6/26/2006
Application Date
Walley Knoll Lot #5
Project Name/Description

RE: Application for single family house, Willow Knoll Lot #5

Upon review of the site plan, the City's Planning Division has the following comments:

PLAN SHOWING A
 TOPOGRAPHIC SURVEY AND
 PROPOSED BUILDING LOCATION
 OF LOT 5, WILLOW KNOLL SUBDIVISION,
 PORTLAND, MAINE
 MADE FOR ROBERT TWOMBLY
 SCALE: 1 INCH = 20 FEET MAY 19, 2006
 SURVEYED BY:
 AUSTIN LAND SURVEYING, LLC
 82 ELDERBERRY LANE
 NEW GLOUCESTER, MAINE 04260
 (207) 632-2959

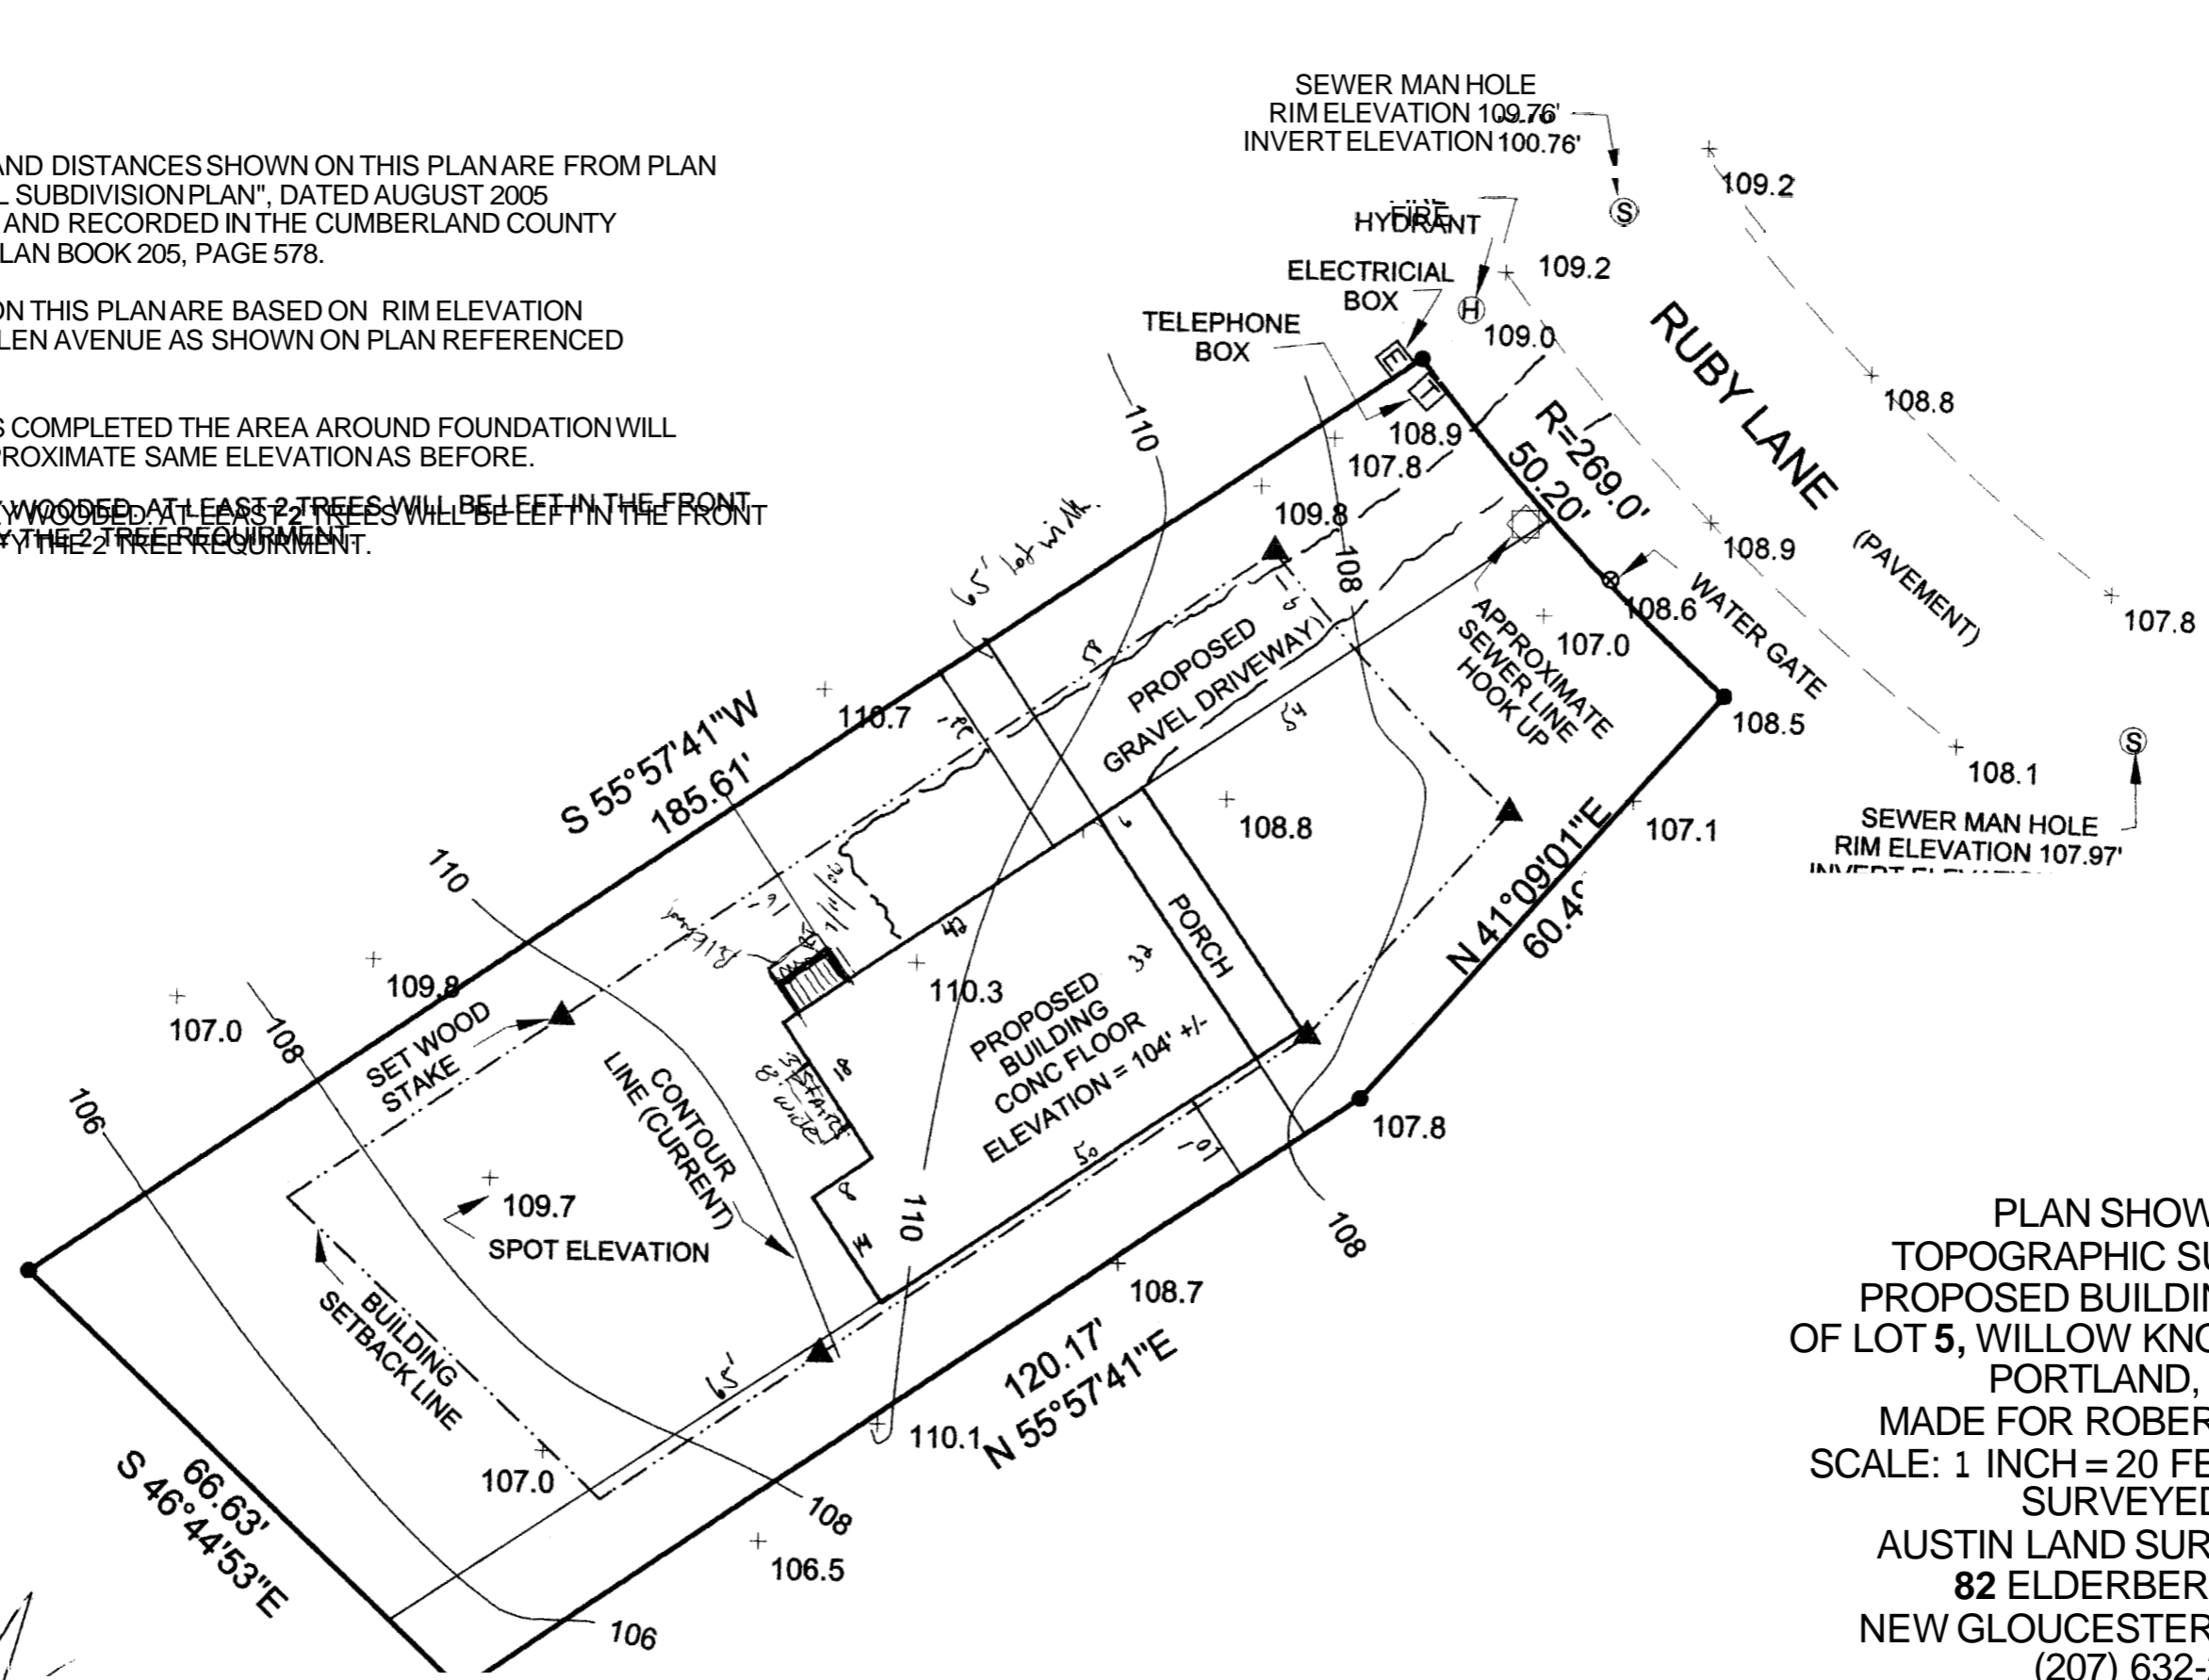
1. For single-family subdivisions, the driveways are required to be paved. Please revise the site plan to note this.
2. Please add erosion control, along the front and rear property lines, to the site plan.
3. Please add 2 street trees (required for single family development, to be installed along the street frontage of the property) to your site plan.
